MEMORANDUM

Subject: Application ID: 2013-228

Comments Submitted by: Marge Schmuckal/Zoning on 12/6/2013

Comments Submitted by: Marge Schmuckal/Zoning on 10/18/2013

SHEET TITLE:  
EAST ELEVATION

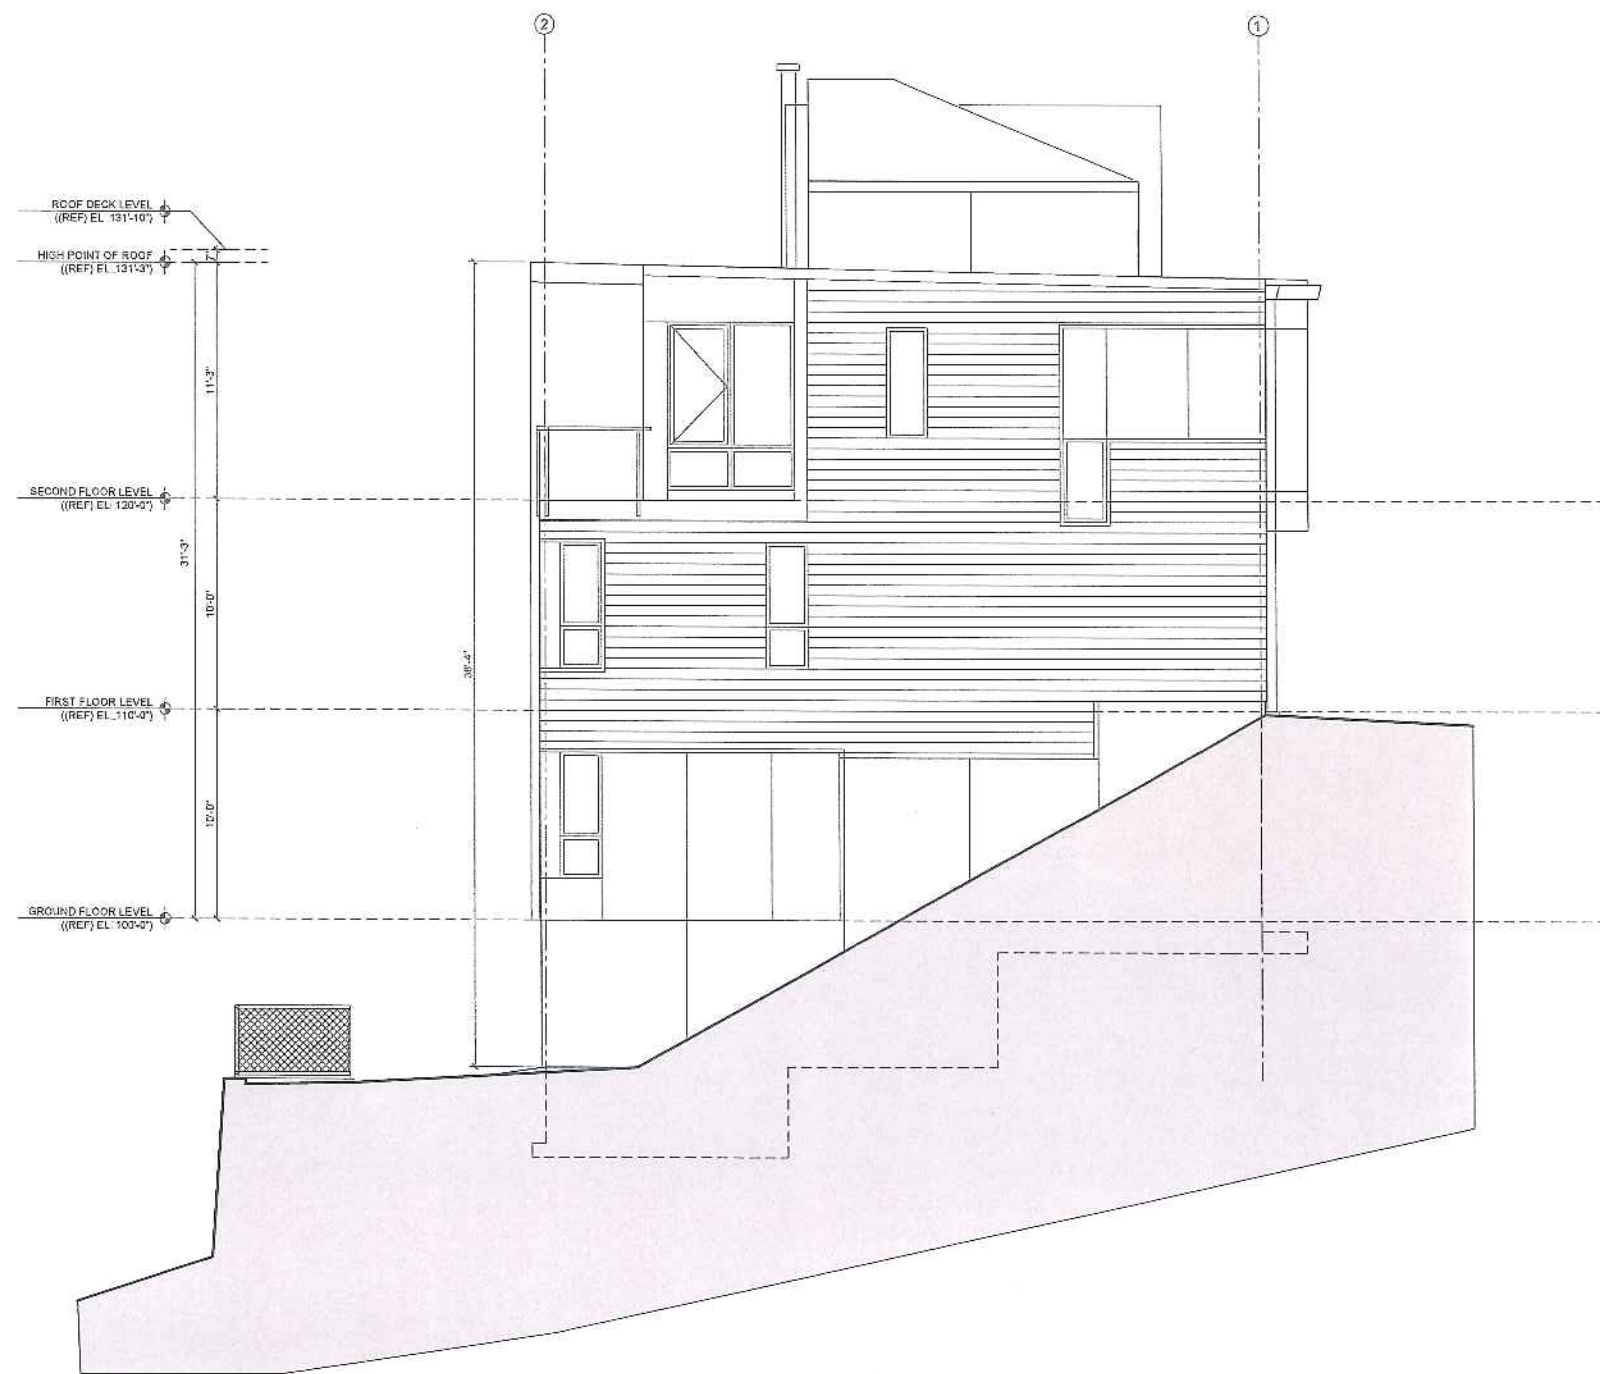
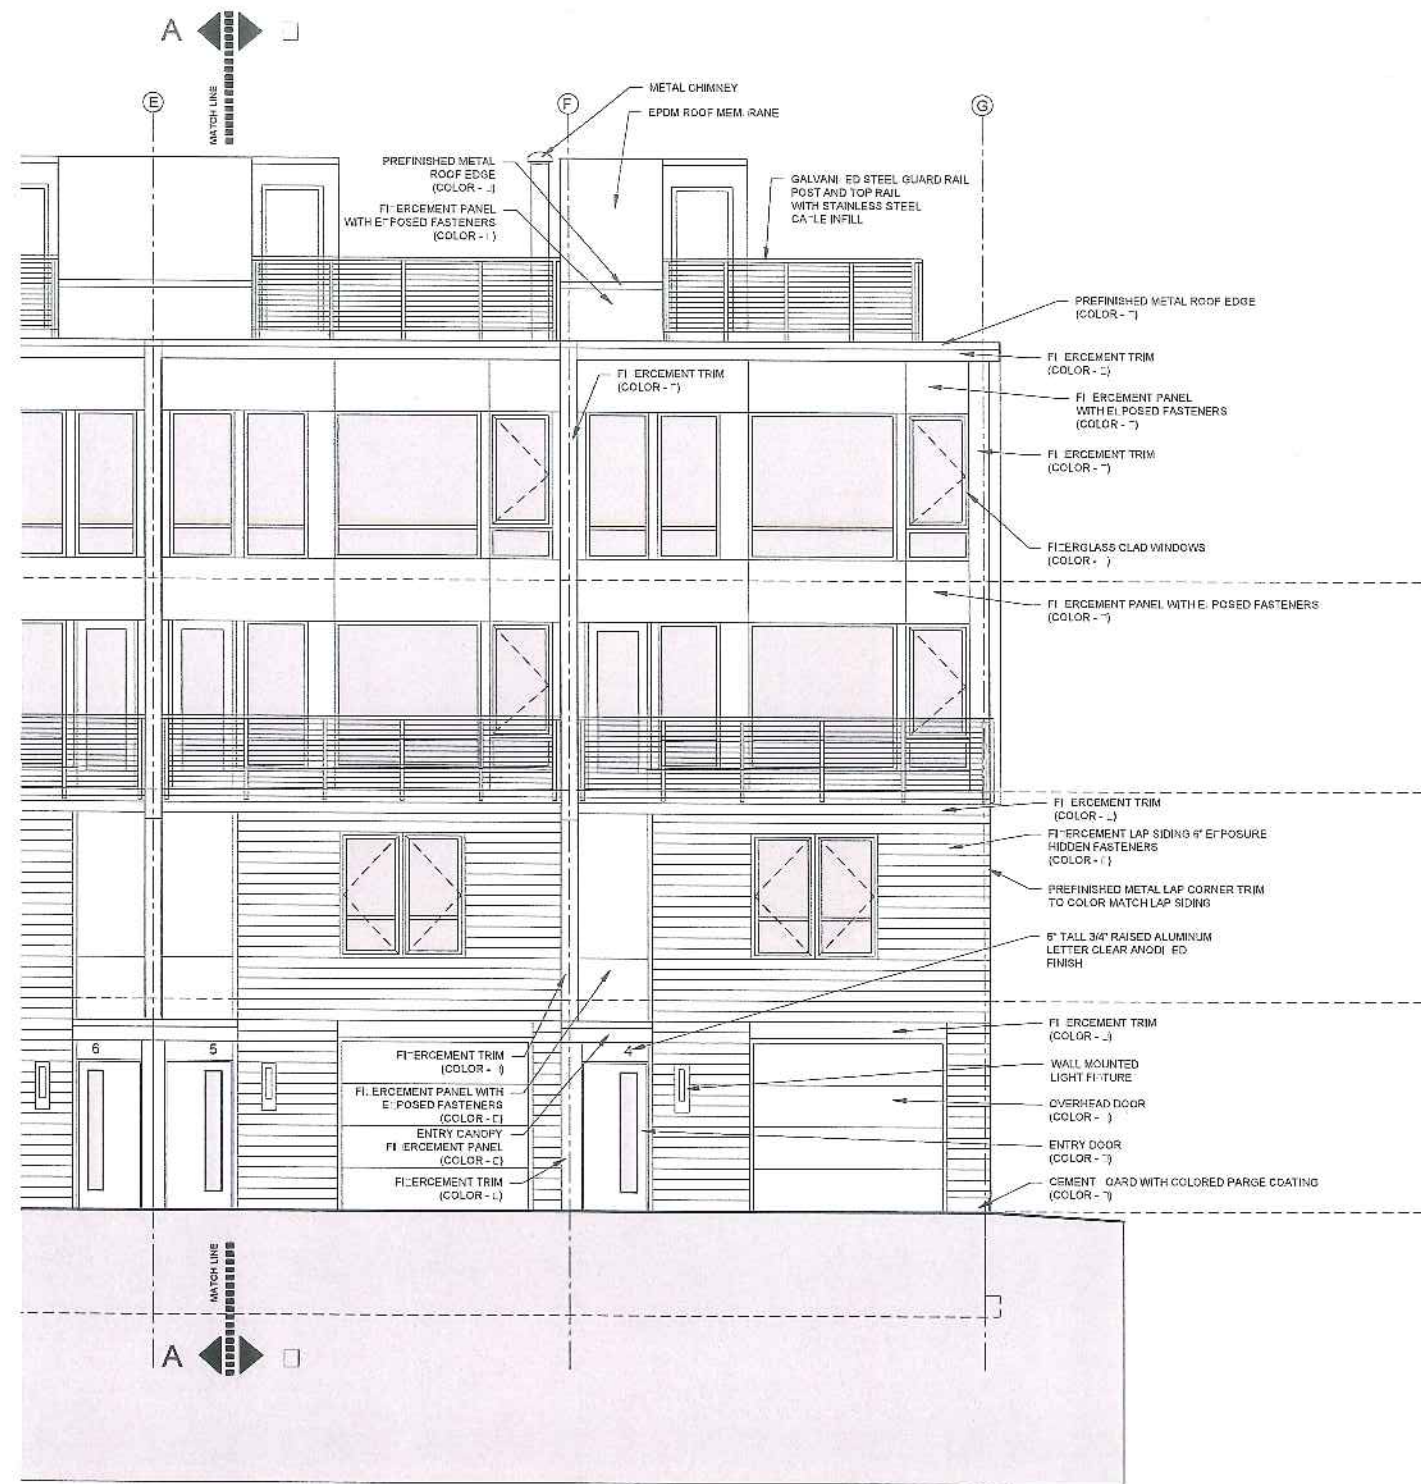
The height requirement appears to be met. However, the narrative mentioned average grades. I did not see the methodology for the average grades. The average grade was not indicated on the building elevations. Please explain the details a little bit more.

Marge's original review comment on 10/18/13 stated that the height requirement appeared to be met, but that the narrative had mentioned average grades, She wanted to see the methodology for the average grade. Based on the email from Ryan Senatore and the Average Grades Diagram dated 12.04.13, the methodology has been shown and the heights for the three story and four story buildings from the average grade is below the 45' maximum hieght requirement.

DRAWING NAME: **SITE LAYOUT PLAN**  
 PROJECT NAME: **MUNJOY HEIGHTS**  
 CLIENT: **REDFERN PROPERTIES, LLC**  
 P.O. BOX 8816, PORTLAND, MAINE 04104

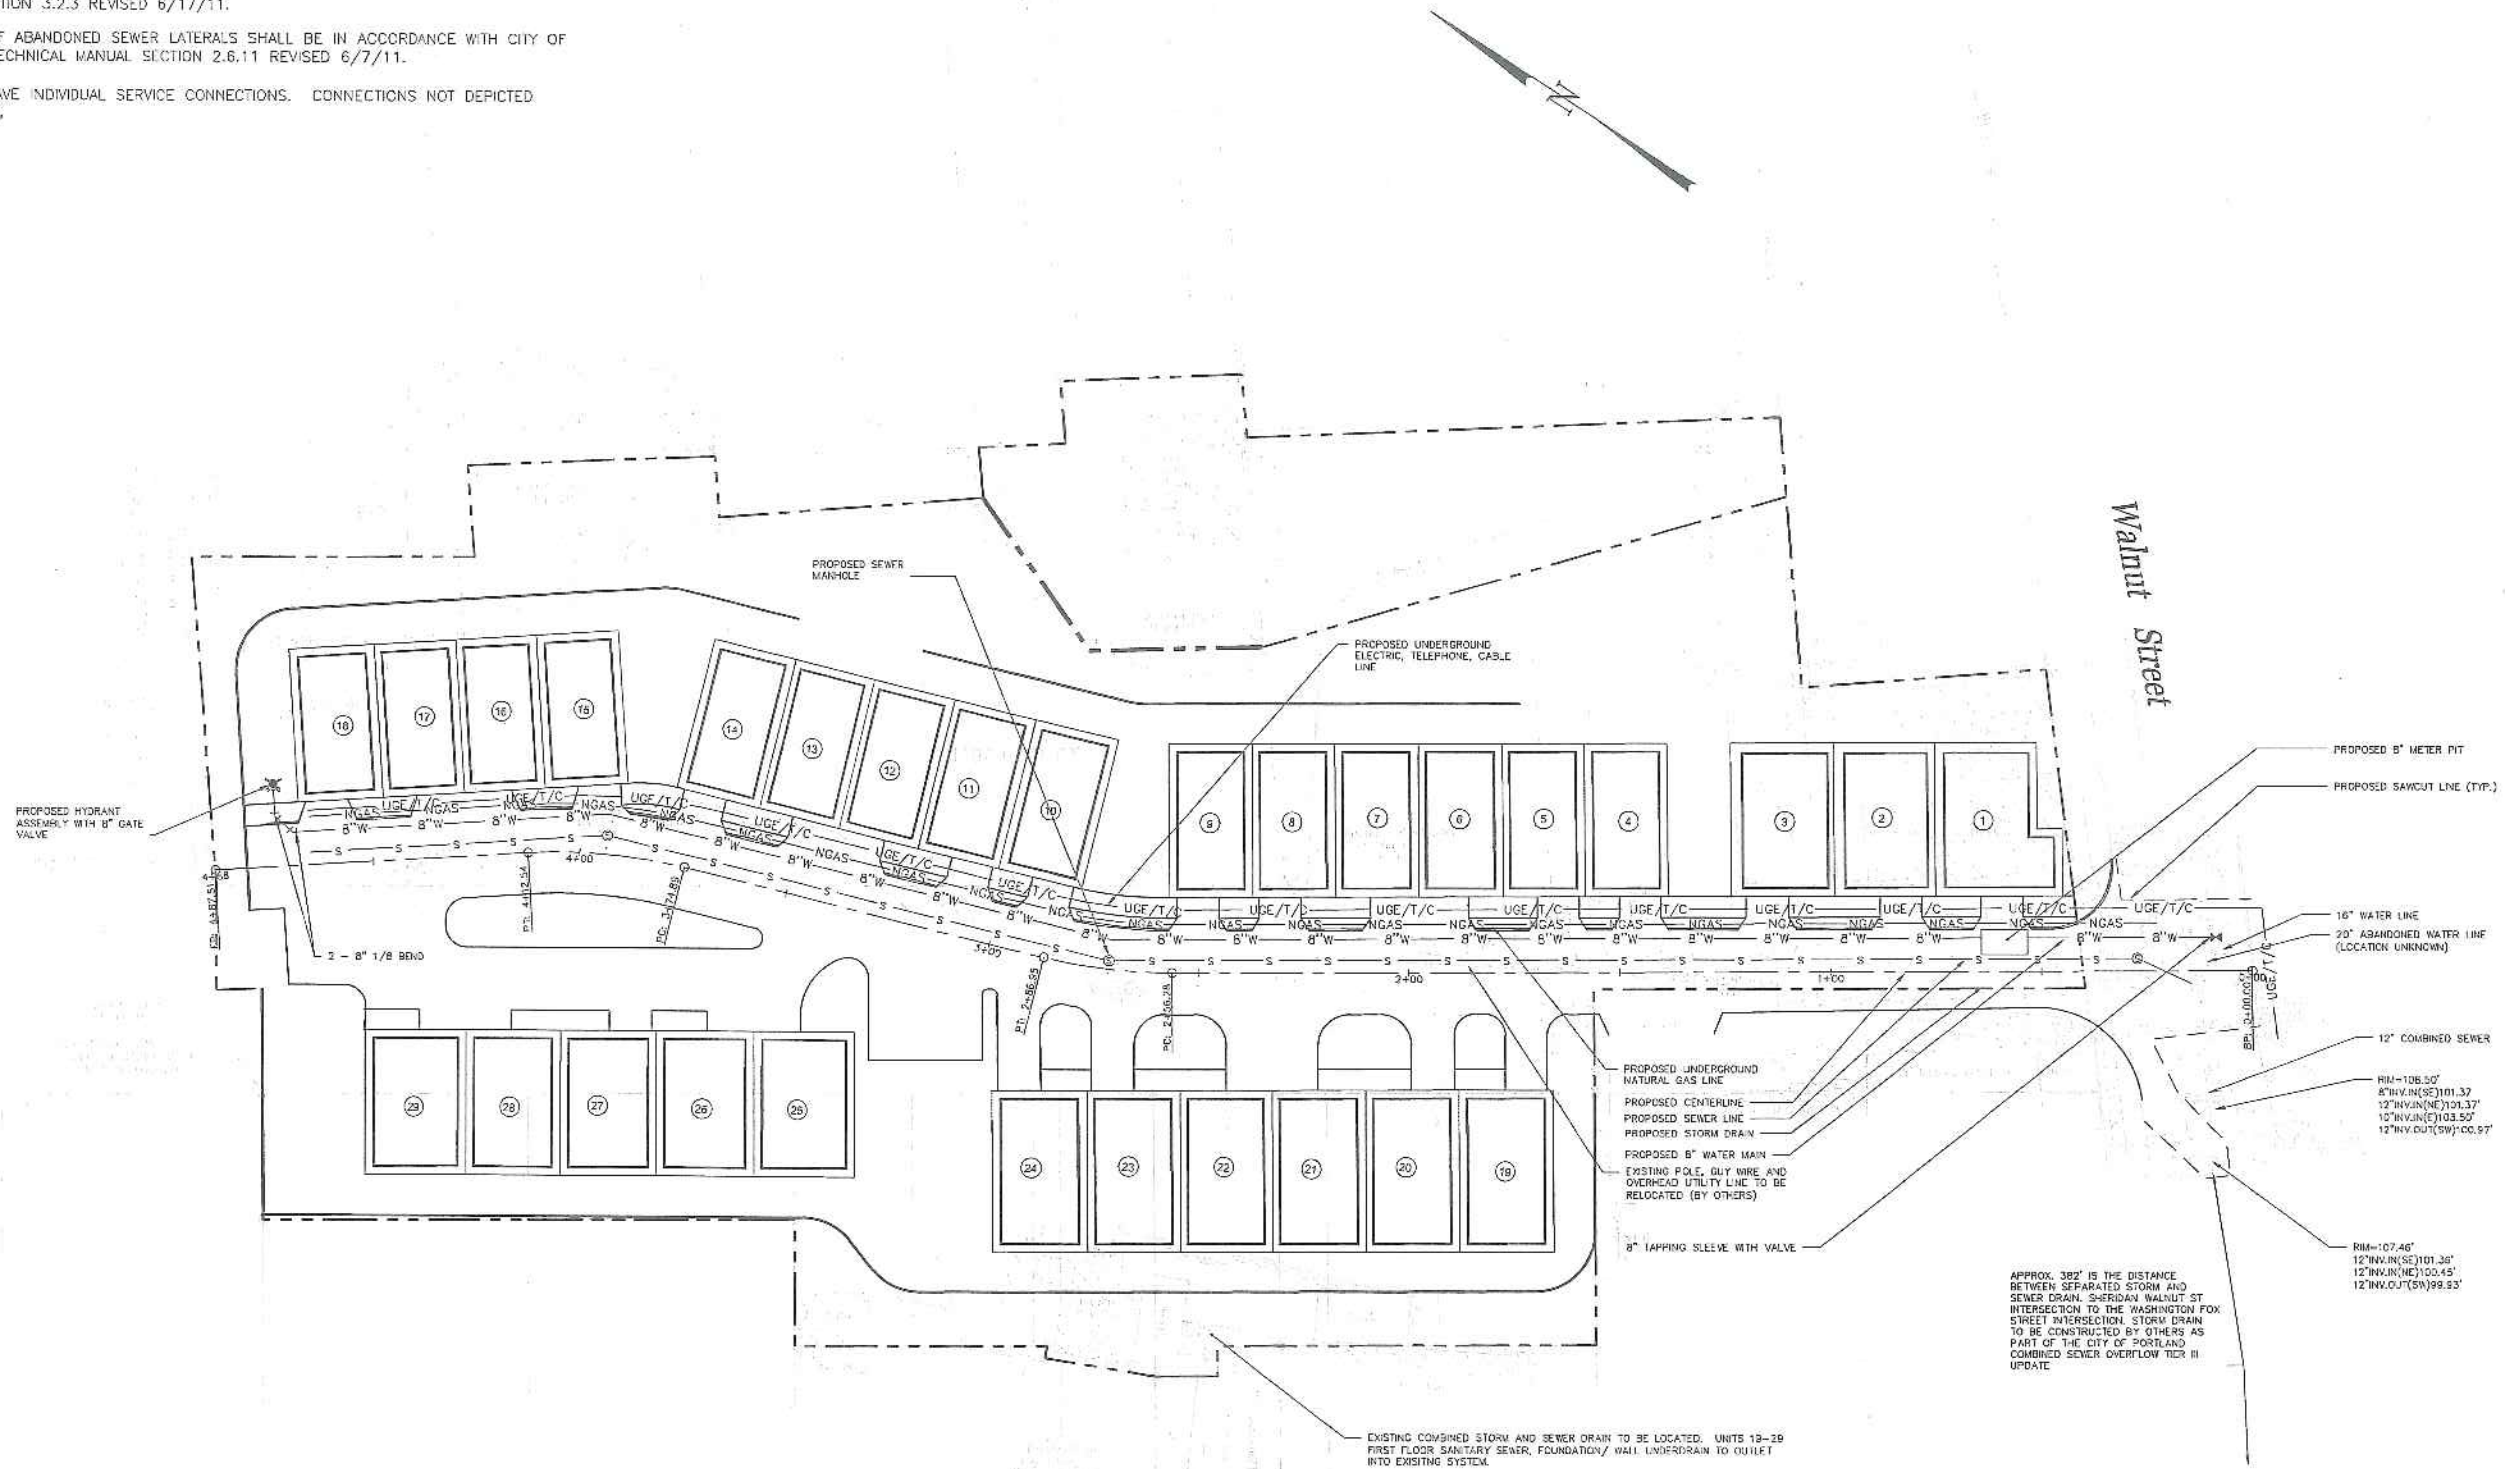
There seem to be two outstanding zoning issues that Marge needed addressed. The first relates to the bumpout on the rear of the building at 128 North Street. It appears that this "bumpout " is a bulkhead which encroaches into the 20' rear yard setback. Section 14-425 allows a "basement bulkhead" whose area does not exceed 50 square feet and which does not project more than 6' from the principal structure to encroach into any required yard setback. The section also stipulates that the bulkhead may not be more than 24 inches in height. If the bulkhead at 128 North Street meets this criteria, then the proposed lot line meets zoning.

The second issue is the utility closet which encroaches into the 20 rear yard setback. Section 14-139(a)(4)(b) states that the rear setback for "principal and attached accessory structures with ground coverage greater than one hundred (100) square feet" is 20 feet. When the accessory structure is attached to the principal structure, it is part of the principal structure and therefore the ground coverage includes the footprint of the principal structure and the attached accessory structure. Since the footprint of both together is over 100 square feet, the utility closet needs to meet the 20' rear setback. At this point it does not. - Ann Machado

I just wanted to be sure on the plans that the "yellow" outline is the edge of the building outline for setback purposes, and not the "black" line. Please confirm.
